**TOWER 2, LEVEL 23
DARLING PARK, 201 SUSSEX ST
SYDNEY NSW 2000**

MP 08_0241 MOD 6

We write in response to submissions received in regard to the Modification 6 application for Major Project 08_0241 at 100 Mount Street North Sydney. We have reviewed the submissions received in consultation with the proponents and provide the attached table of response on their behalf.

RESPONSE TO SUBMISSIONS MP 08_0241 MOD 6

2 MOD06_March 21st 9am
SCALE: 1 : 1000

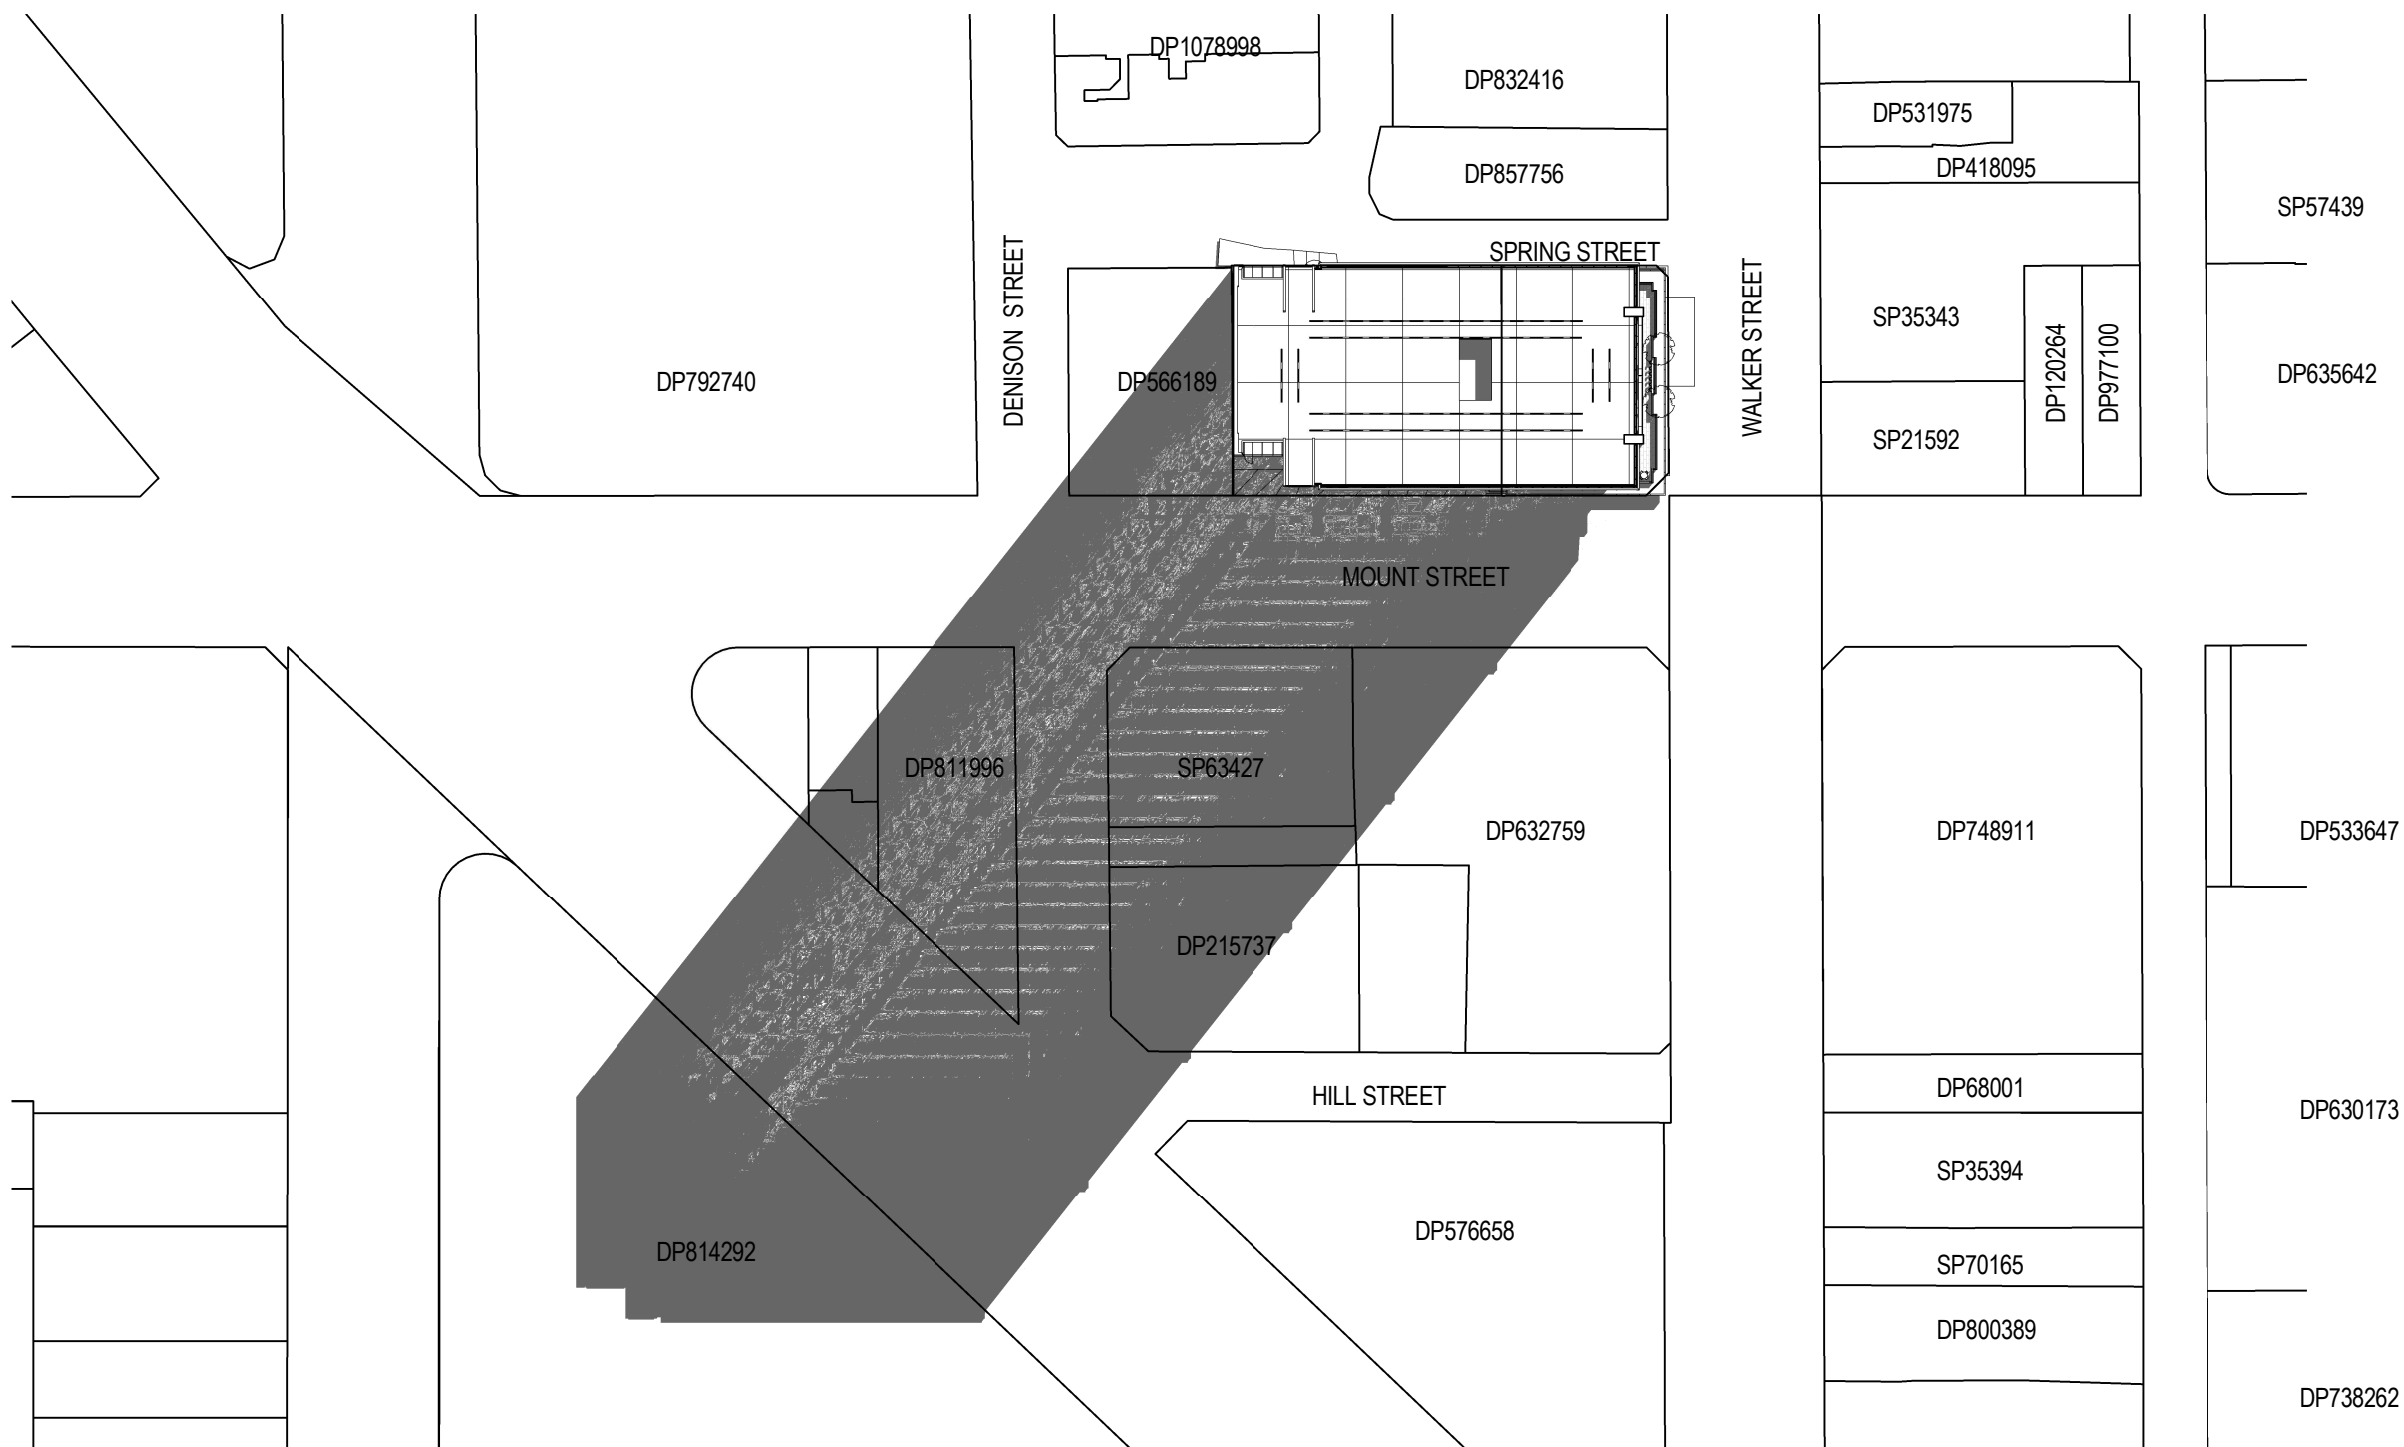
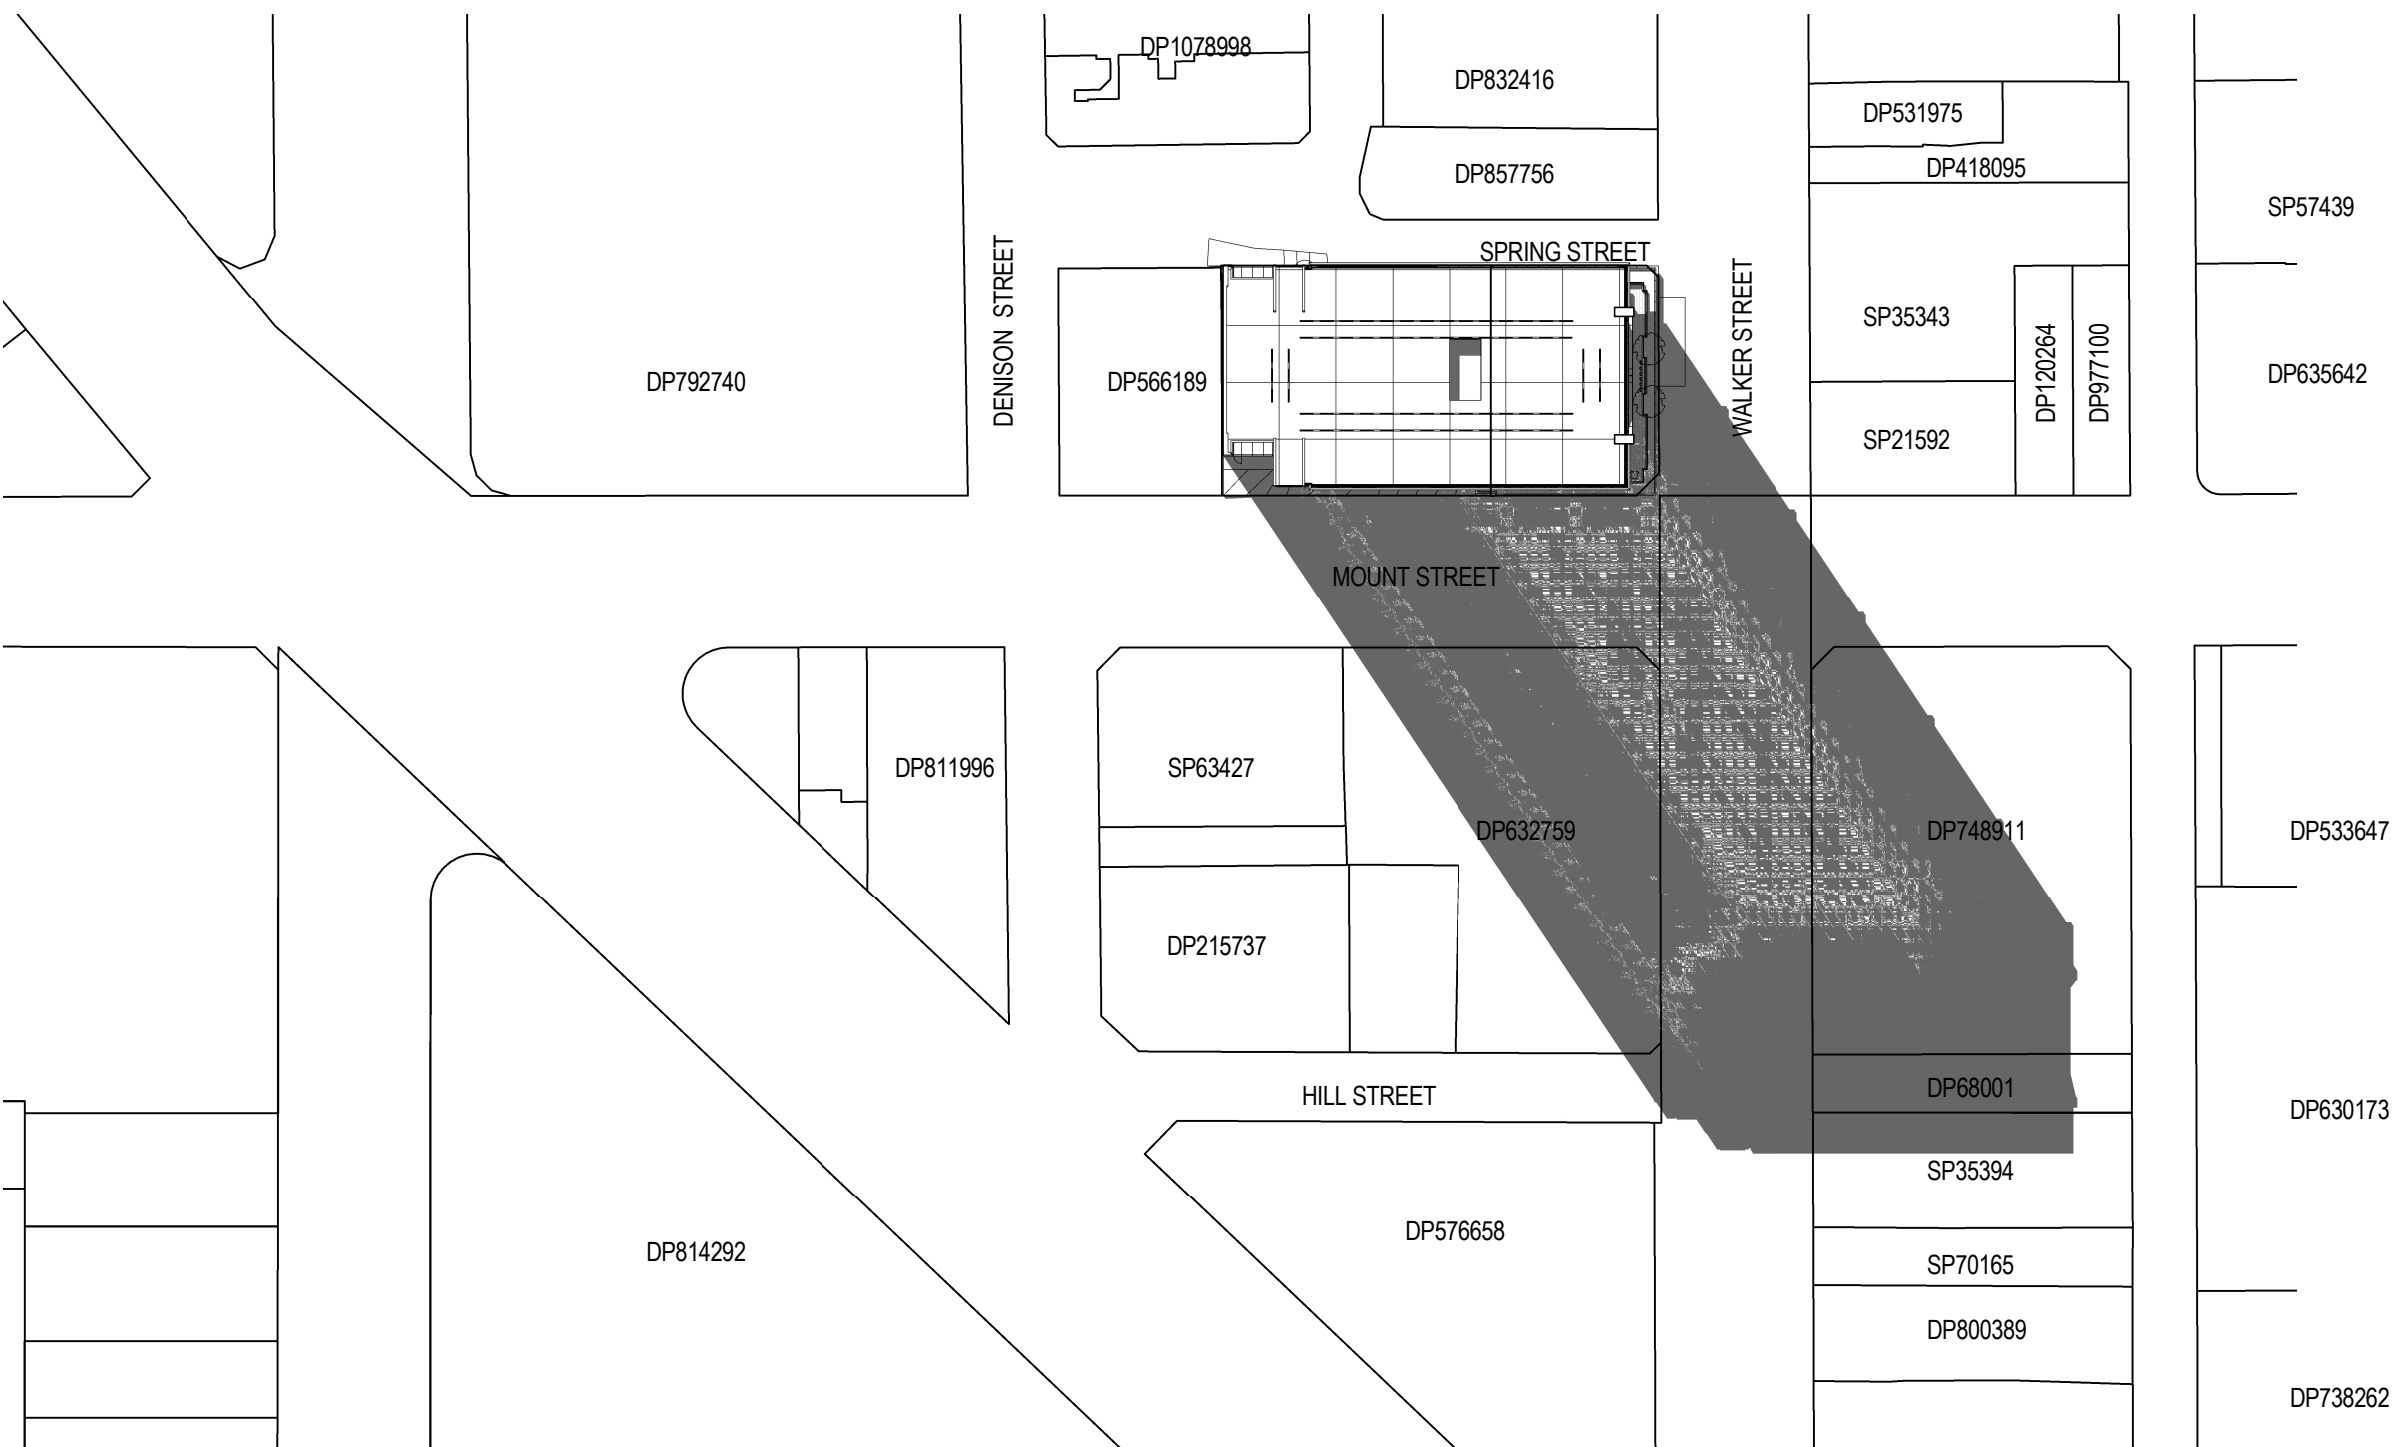
Submission	Issue/Comment	Response
	Views <i>The proposed development...is considered to significantly obstruct the views of the Beau Monde building.</i>	The proposed development which includes an additional 3.4m in height to accommodate the lift overrun and building maintenance facility will not significantly obstruct the views of the Beau Monde building. The existing bulk and scale of the building to the top of building façade remains unchanged at RL199.7.
	Solar Access <i>Although, it is acknowledged that the Beau Monde building, being located north of the development site, will not be the subject of overshadowing, this submission seeks also to articulate the wider public interest...the additional building height will further increase overshadowing with negative implications for many properties located to the south of the site.</i>	The proposal will not overshadow the Beau Monde building which is located north of the site. Shadow analysis diagrams provided with the application show that no new properties are impacted by the additional 3.4m in height. No adverse impact on solar access will result from the proposal.
